**RE: Harnett County Land Use Existing Tank Application #10-5- 24422**

The Harnett County Department of Public Health, Environmental Health Division on 5-19-10, evaluated the above referenced property at the site designated on the plat/site plan that accompanied your existing tank application. According to your application requesting a pergola, the evaluation was done in accordance with the laws and rules governing wastewater systems in North Carolina General Statute 18A.1950 including related statutes and Title 15A, Subchapter 18A, of the North Carolina Administrative Code, Rule.1950 and related rules.

Based on the criteria set out in Title 15A, Subchapter 18A, of the North Carolina Administrative Code, Rules .1950, the evaluation indicated that the site is **UNSUITABLE** for the addition requested. Therefore, your request for an existing tank is **DENIED**. The site is denied based on the following:

Date 5-10-10 Zoning Administrator [Signature] plot plan

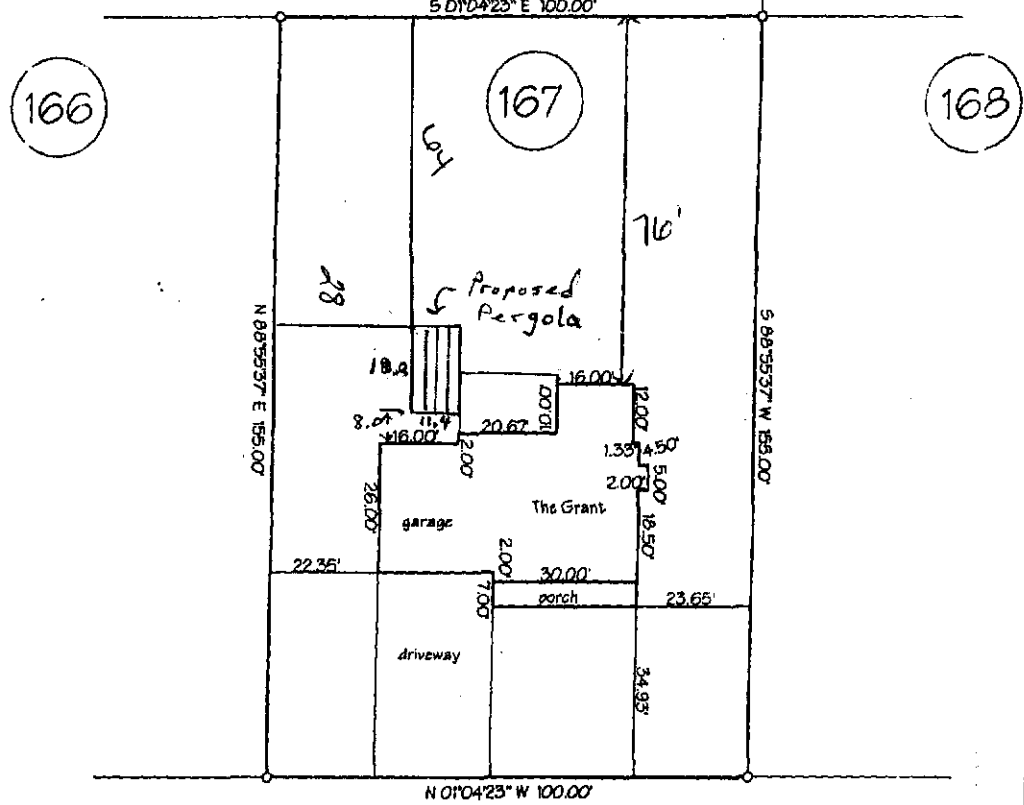
X  15A NCAC 18A.1950 {10} - Any building to be 5' from drain line.

**Option # 1- Move pergola so that it is not on top of drain field and is 5' from any part of the septic system.**

**Option # 2- Relocate septic tank and drain field so that its new location is 5' from the pergola. This will require a soil evaluation and related fees.**
